An
Coimisiún
Pleanála

Inspector's Report ACP322821-25

Question	Whether an extension to the rear of a dwelling is or is not exempted development.
Location	8 Clonmore, Kilteragh, Dooradoyle, Limerick.
Declaration	
Planning Authority	Limerick City and County Council.
Planning Authority Reference.	EC/107/25
Applicant for Declaration	Mubin Merchant
Planning Authority Decision	Is not exempted development.
Referral	First Party
Referred by	Mubin Merchant
Owner Occupier	Mubin Merchant
Observer(s)	None.
Date of Site Inspection	4 th September 2024.
Inspector	Derek Daly.

FLOOR PLAN & SITE LAYOUT PLAN

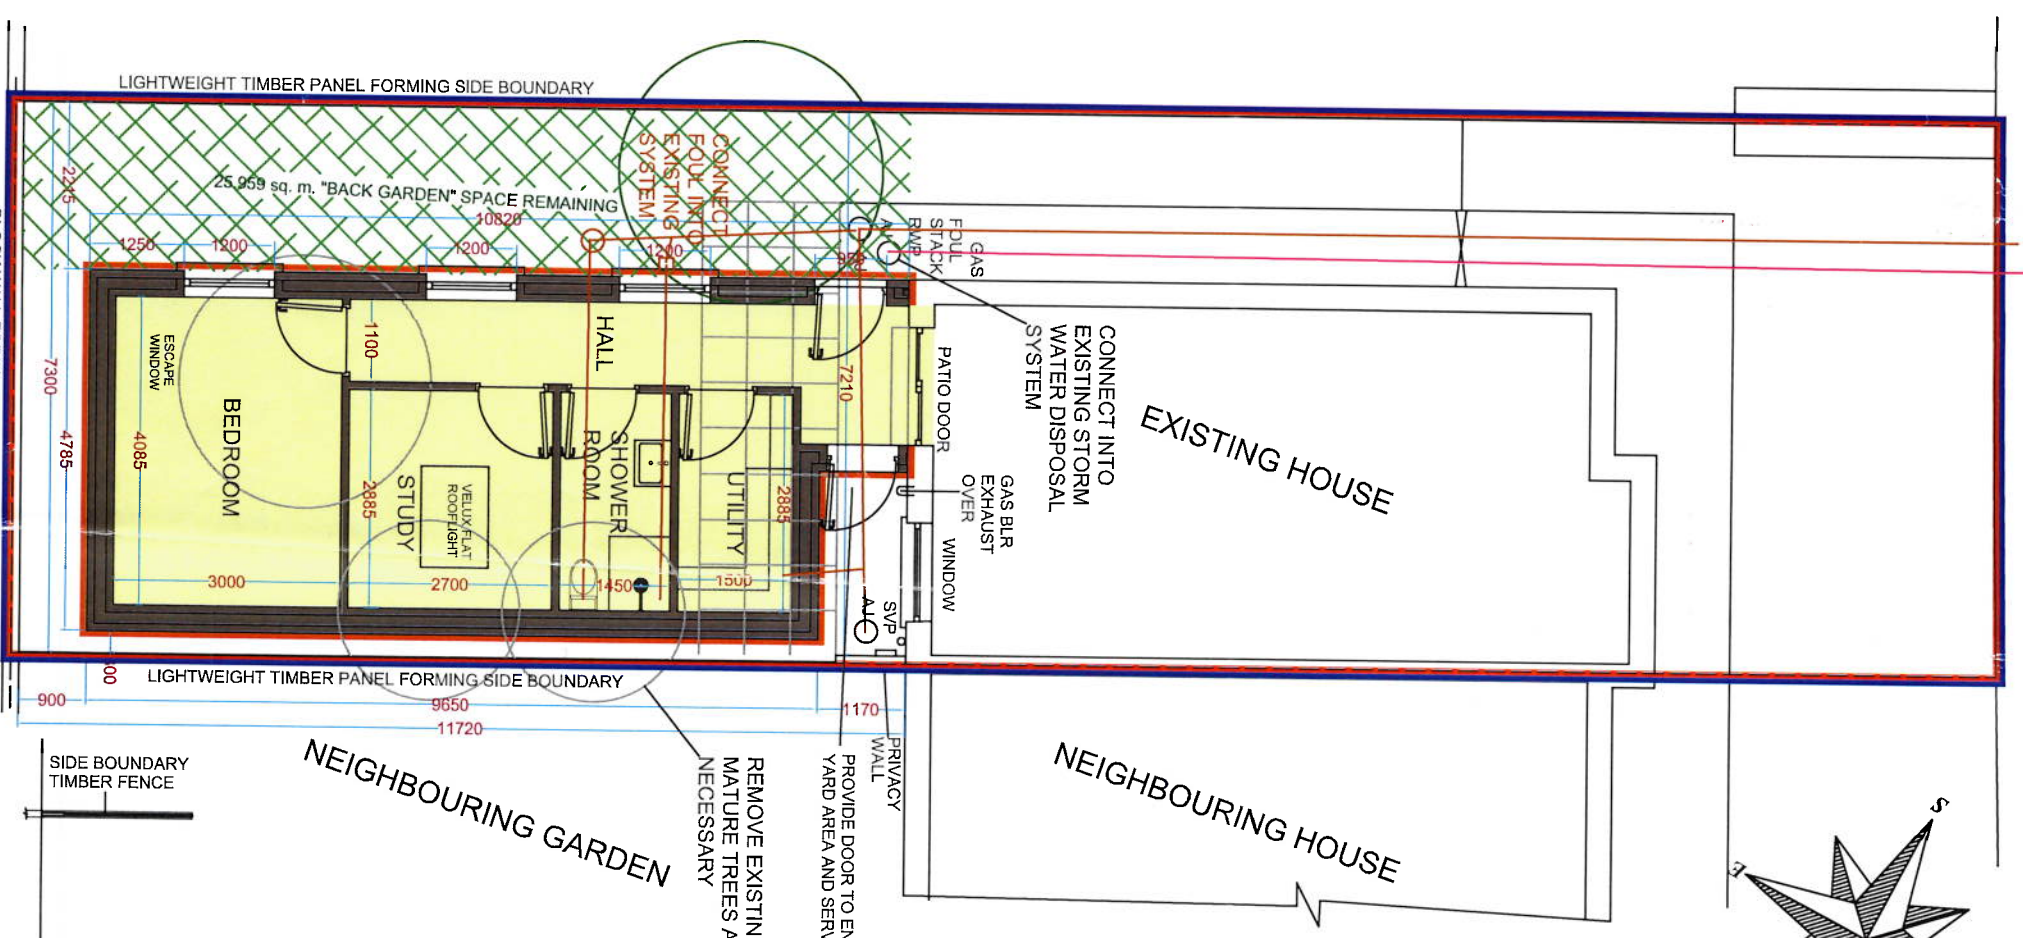
Condition no. 5. The construction or erection of any such extension to the rear of the house shall not reduce the area of private open space, reserved exclusively for the use of the occupants of the house, to the rear of the house to less than 25 square metres.

- 8.4. The matter to consider is condition and limitation 5 which the planning authority in their declaration considers would reduce the area of private open space, reserved exclusively for the use of the occupants of the house, to the rear of the house to less than 25 square metres.

- 8.4.3. The proposal as indicated on the drawings and documentation will provide an area of private open space, reserved exclusively for the use of the occupants of the house, of in excess of 25 square metres.

- 8.4.4. Based on the documentation submitted the construction or erection of any such extension to the rear of the house does not reduce the area of private open space, reserved exclusively for the use of the occupants of the house, to the rear of the house to less than 25 square metres.

- 8.4.5. The wording of condition no.5 does not expressly state that the reserved 25 square metres of open space must be to the rear of the extension or an extended area of the dwelling and it can I consider be interpreted that reference to the rear of the house is based on the original and in this case current rear building line of the house, and that the present area of open space to be retained is greater than 25 square metres of open space. It is noted in this regard that in the inspector's report of RL2506 that the "rear of the house is confined to the area beyond the rear wall of the main house" which can be interpreted I consider to the original rear wall of the house
